**Re: Review of Proponent Response  
Dargues Reef Gold Project, Major Project Application No. 10\_0054**

Southern Rivers Catchment Management Authority (CMA) does not support the project and the current amendments proposed by Cortona Resources Limited. The proponent's response to the submission does not adequately address Southern Rivers CMA's concerns.

**Re: Review of Dargues Reef Gold Project, Reference Number: 2010/5770**

Figure 5
PROJECT SITE LAYOUT

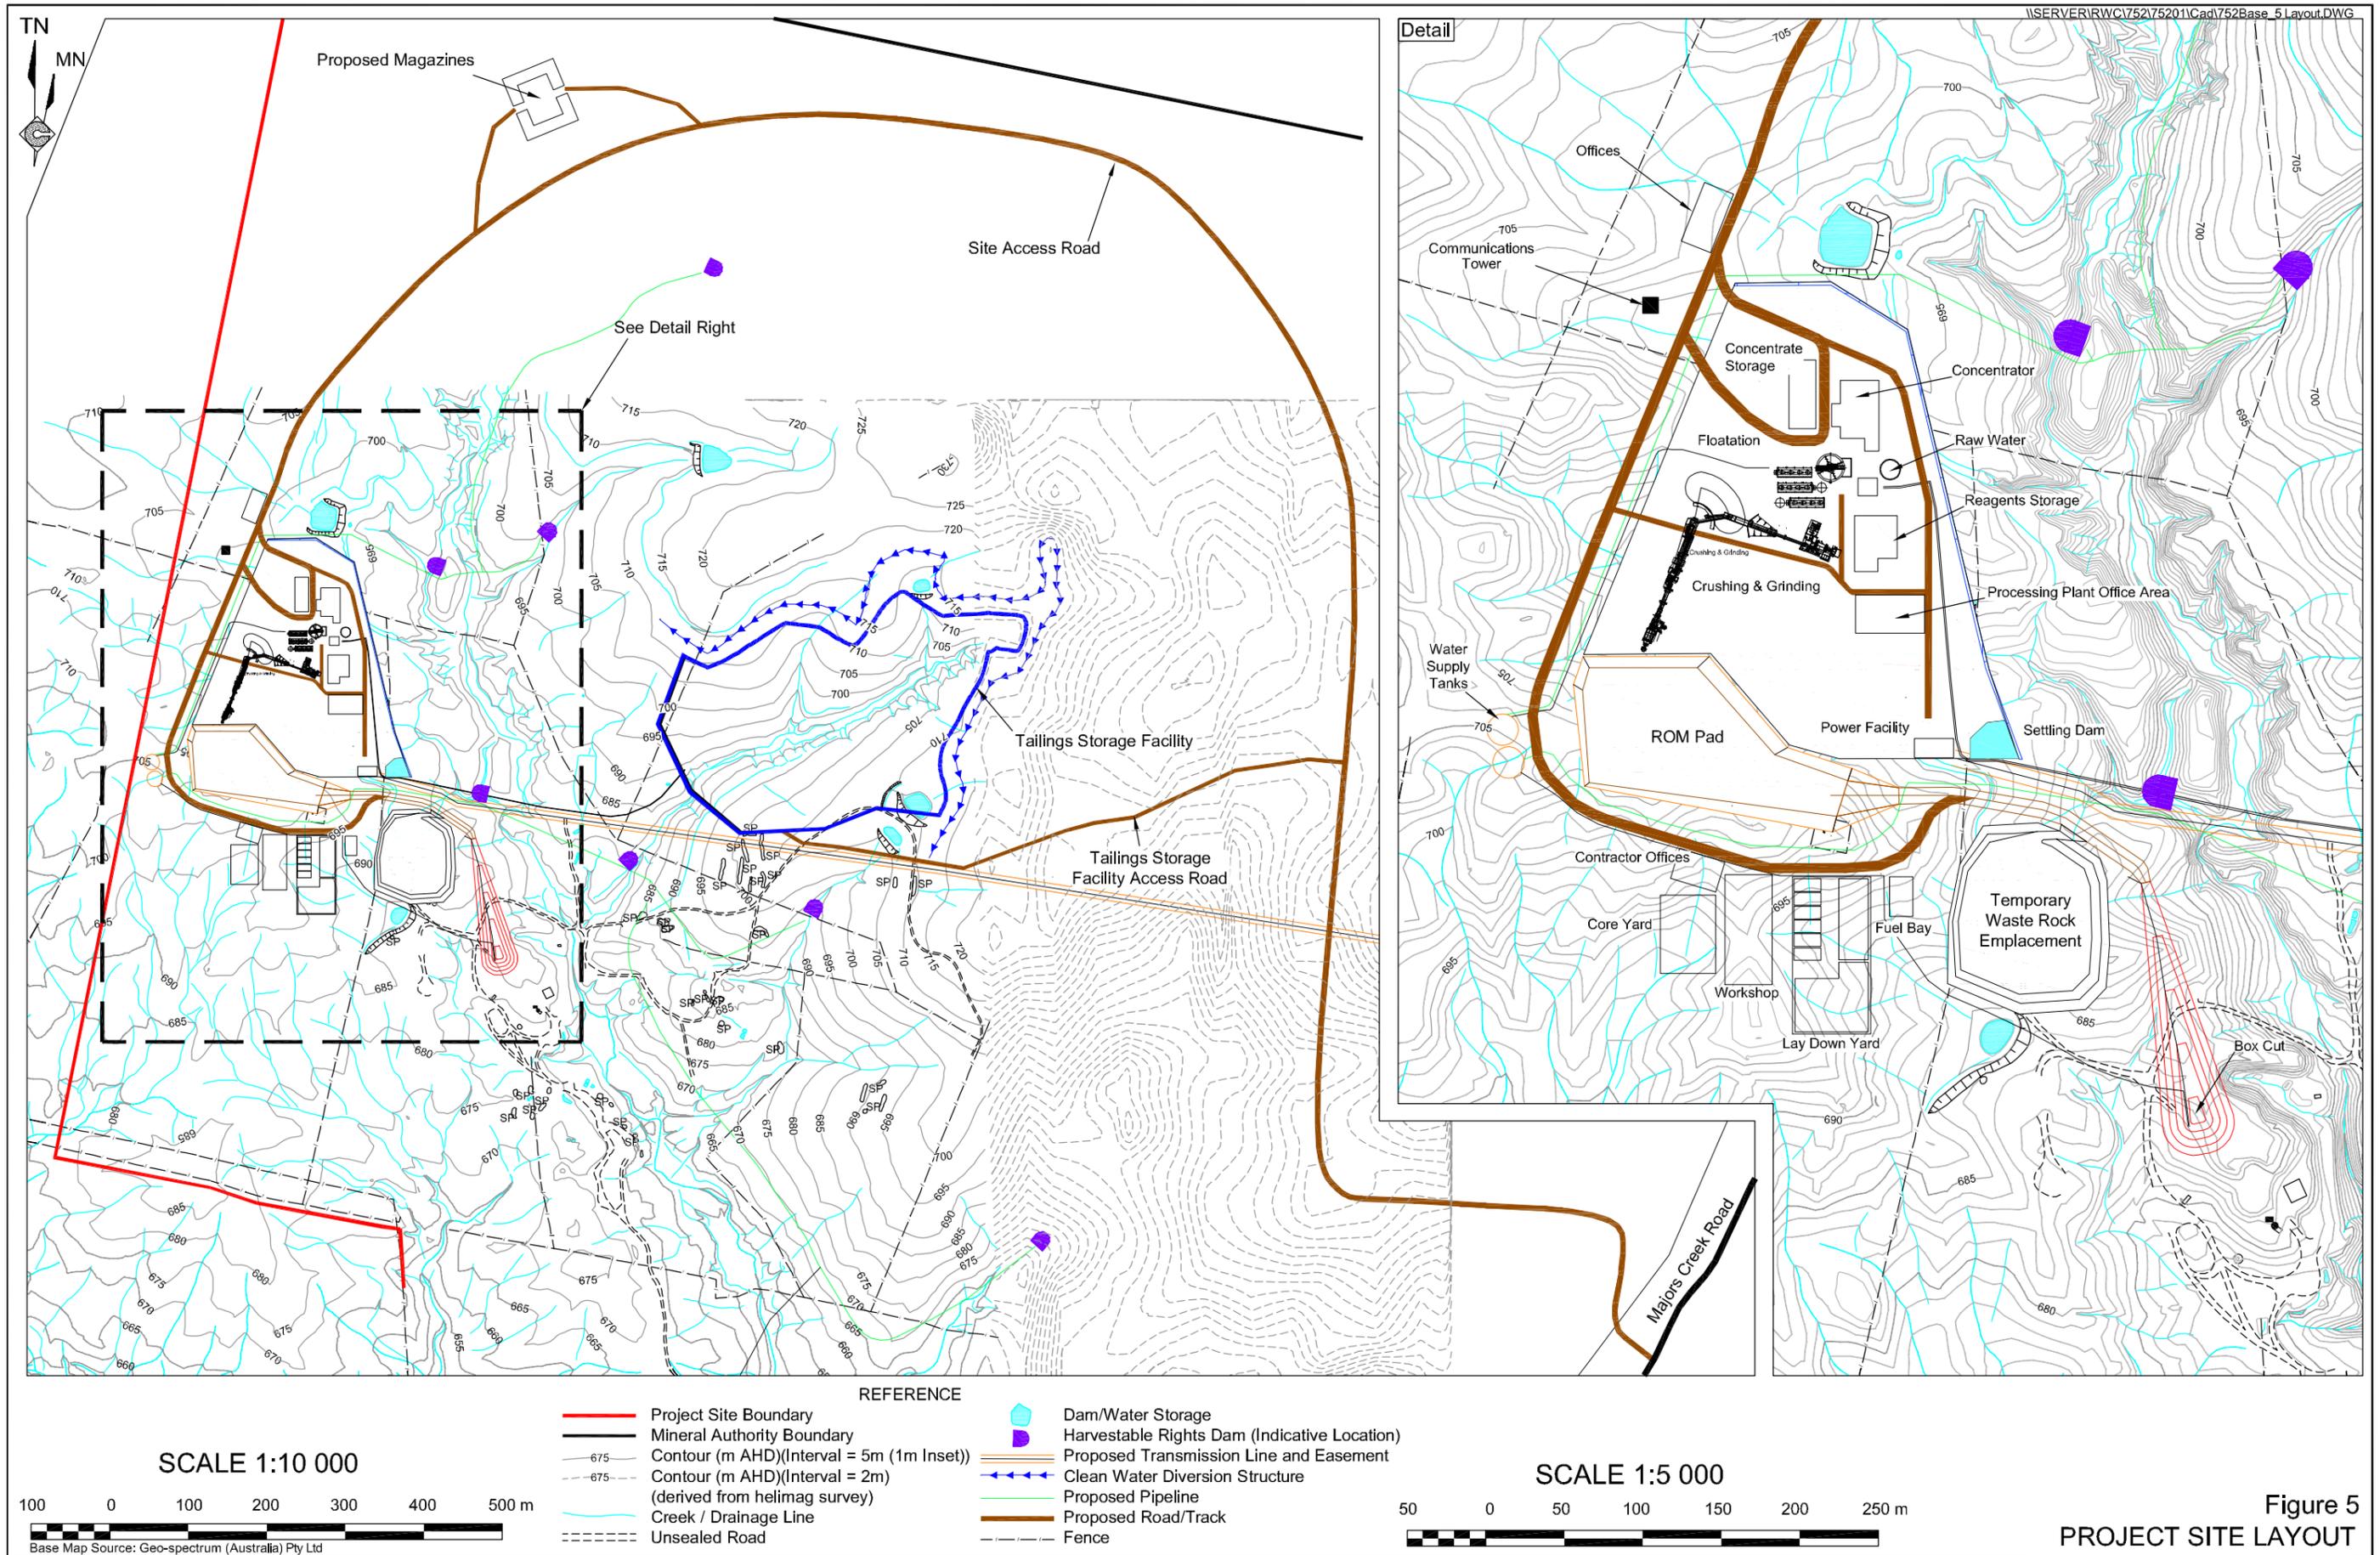
**Loss of normal surface water flows into Majors Creek through the construction of eight new farm dams (in addition to the 14 existing farm dams on the property).**

- Cortona argue that the construction of the dams is within their harvestable right, and that the water will occasionally be released to augment flow. However there is also the additional tailings storage facility (TSF), which is proposed to be 9.3 Ha in area, with a capacity to store approximately 900,000m<sup>3</sup> of material, including accumulated water in the collection pond. This structure has not been included in the consideration of harvestable right, and will store substantial quantities of water.
- The TSF will also hold the thickened slurry that is the by product of gold processing. All additional dams proposed, including the tailing stage facility, will disrupt catchment flows to Spring Creek and Majors Creek.
